Application for approval of details reserved by condition.
Town and Country Planning Act 1990
Planning (Listed Buildings and Conservation Areas) Act 1990

Demolition of existing 2 storey detached house & construction of a pair of semi-detached replacement dwellings with flood preventative measures.

BN/23/15/PL

I can now confirm the following comments in respect to the surface water drainage;

Record of As Bolt Construction

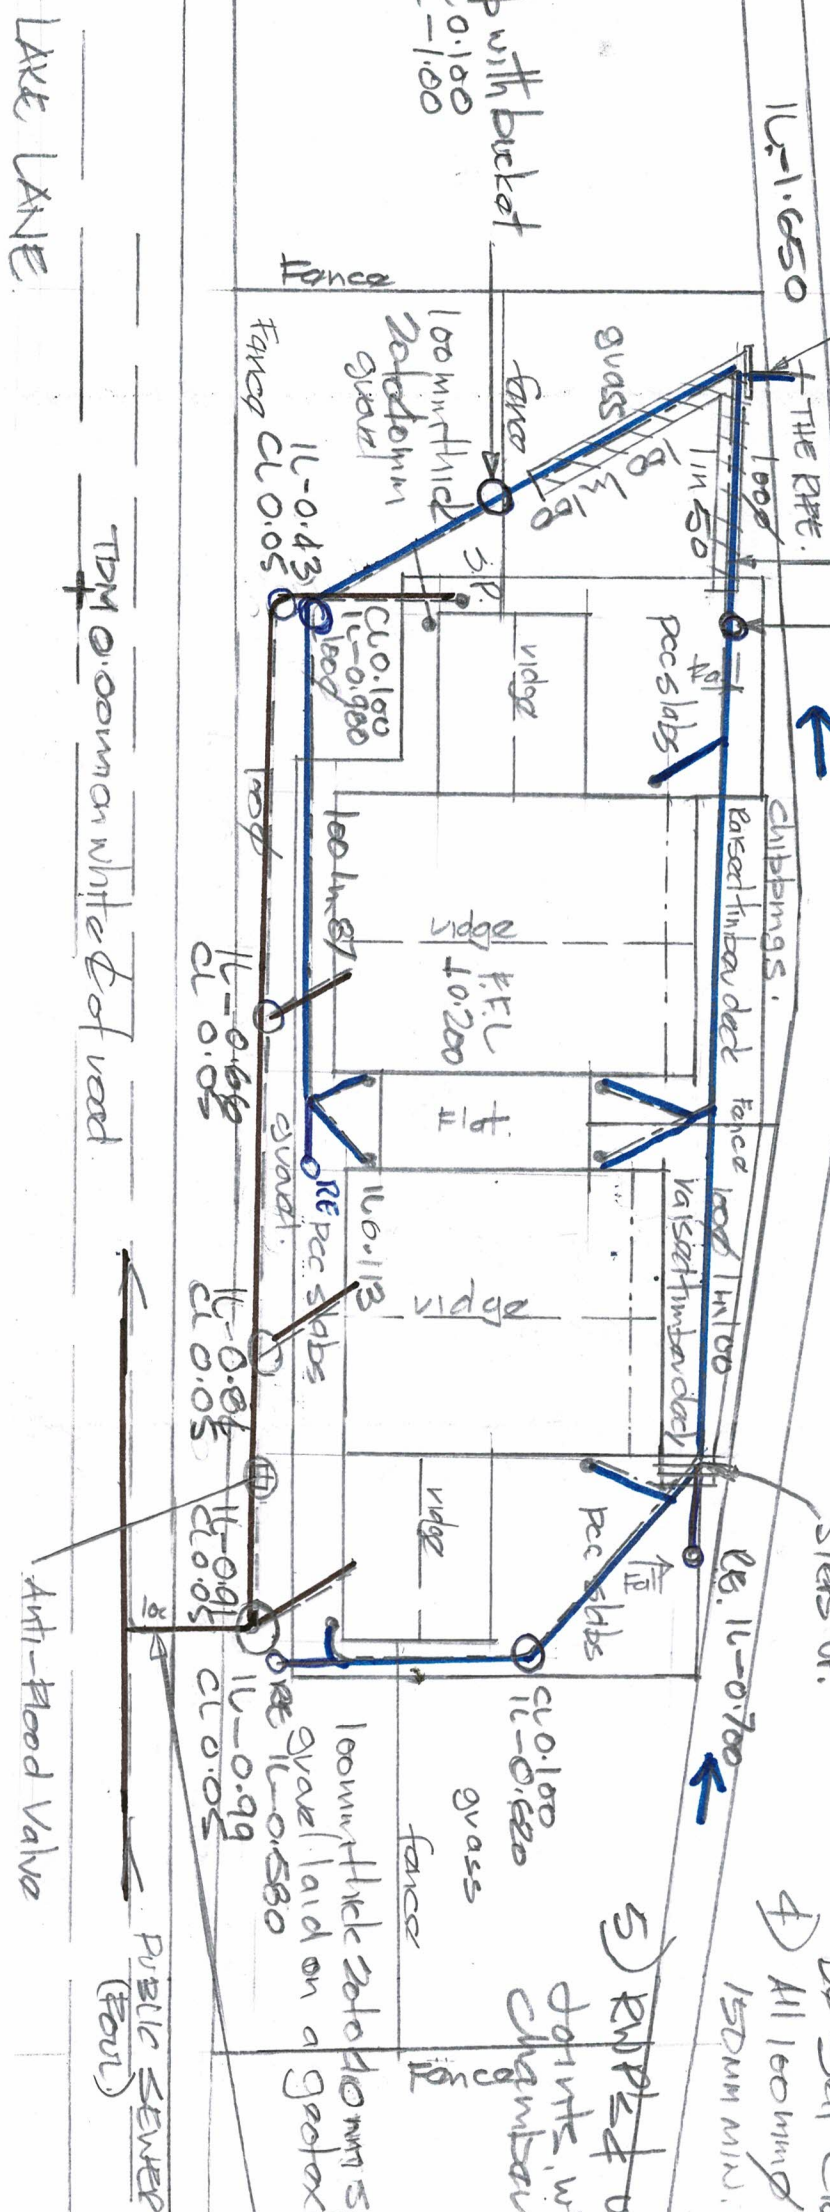
1. As the plan still does not show any manhole positions except the two proposed silt traps, I can only assume no other manholes exist or are proposed. However, to provide means of access for maintenance/inspection and follow good practice of providing access on changes of pipe direction, further manholes are required. Rodding eyes can be provided at heads of run. Cover and invert levels will be required for these access points.

2. The manhole detail shown on the drawing should be labelled as 'Type E' to correspond with the relevant note on drg. 535/01 Rev C. The detail shows the manhole cover being buried under 100mm thick gravel which is not acceptable. Manhole covers need to be visible/easily accessible. Please alter.

3. Provide construction detail for the sump manholes. Minimum requirements are 450mm diameter chambers with min. 300mm deep sumps. Cover and invert levels will be required for these.

4. Pipe gradients to be shown for each pipe length once manhole positions have been indicated. I note item 3 on 535/01 rev C specifying an approx. gradient of 1 in 59 based upon an assumption. These gradients will need to be more accurately assessed and this can be done once excavations have been made to accommodate manholes, etc, and therefore levels can be obtained at that time.

6. I note from the levels that the perforated pipes are around 1m below ground level. Due to the high water table in this area it is likely that groundwater will flow into these pipes at times, rather than surface water being able to infiltrate into the surrounding ground (be it minimal infiltration due to the ground conditions). This is not ideal as we try to avoid groundwater being drained into the watercourse directly (properties flood downstream), but in this instance (due the minimal flows involved), I am not going to make a big issue about it.
